June 6, 2006

**Re: Status of Improvement Permit Application #06-5-14615R Lt. 107 Forest Oaks
2nd Request**

**RE: Harnett County Land Use Application 06-5-14615 Lt 107 Forest Oaks
06-5-14608 Lt 96 Forest Oaks**

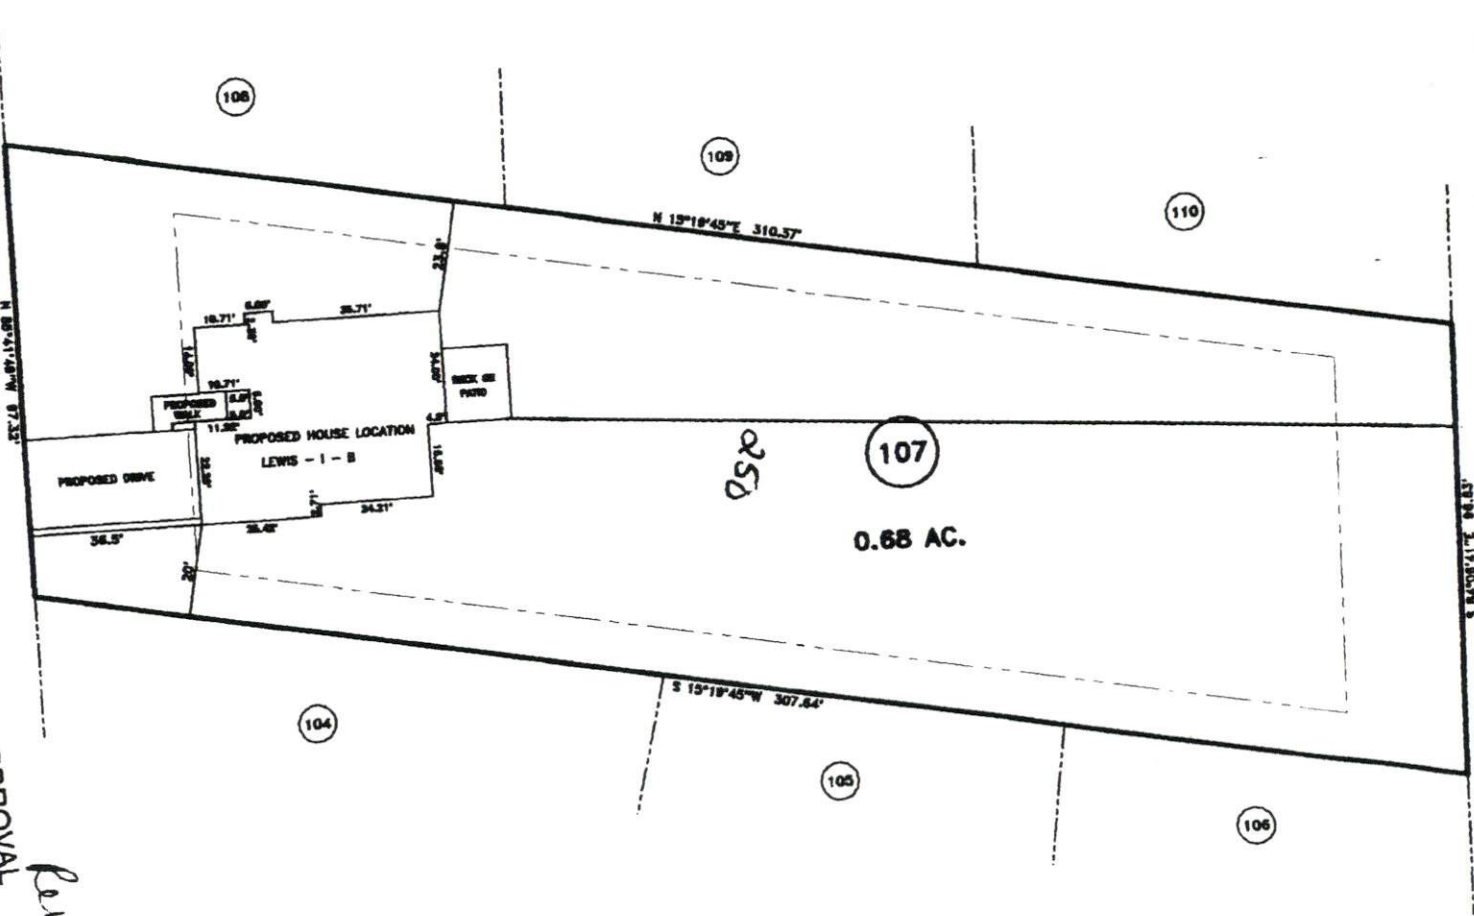
- 1. Property lines/corners not marked or labeled
- 2. House corners not marked or labeled
- 3. Directions not clear to property
- 4. Property needs brush or vegetation removed
- 5. Backhoe pits required
- 6. Other – **Get consultant to provide layout for this lot. Your revision was received but the layout for this lot was not provided with the revised application that we received on June 5, 2006.**

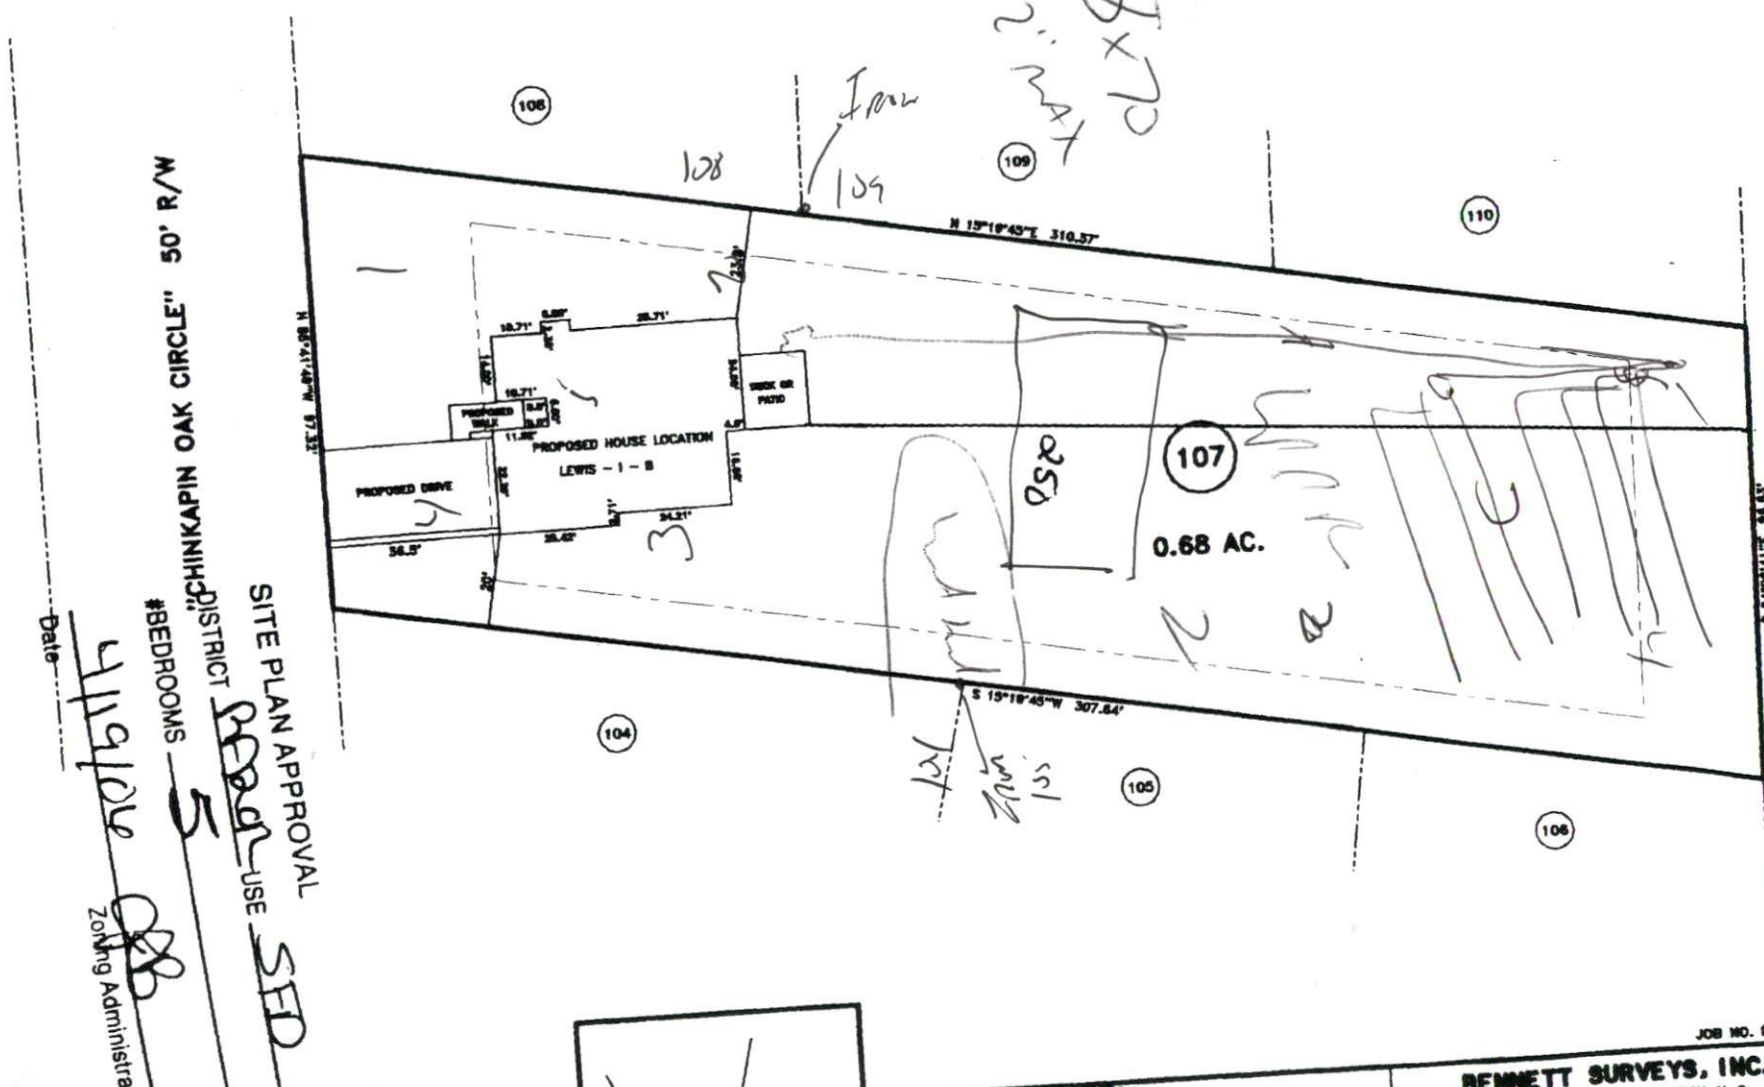
- 1. Property lines/corners not marked or labeled
- 2. House corners not marked or labeled
- 3. Directions not clear to property
- 4. Property needs brush or vegetation removed
- 5. Backhoe pits required
- 6. Other **Please have your private soil consultant provide septic and repair system layout for 5 bedroom home.**
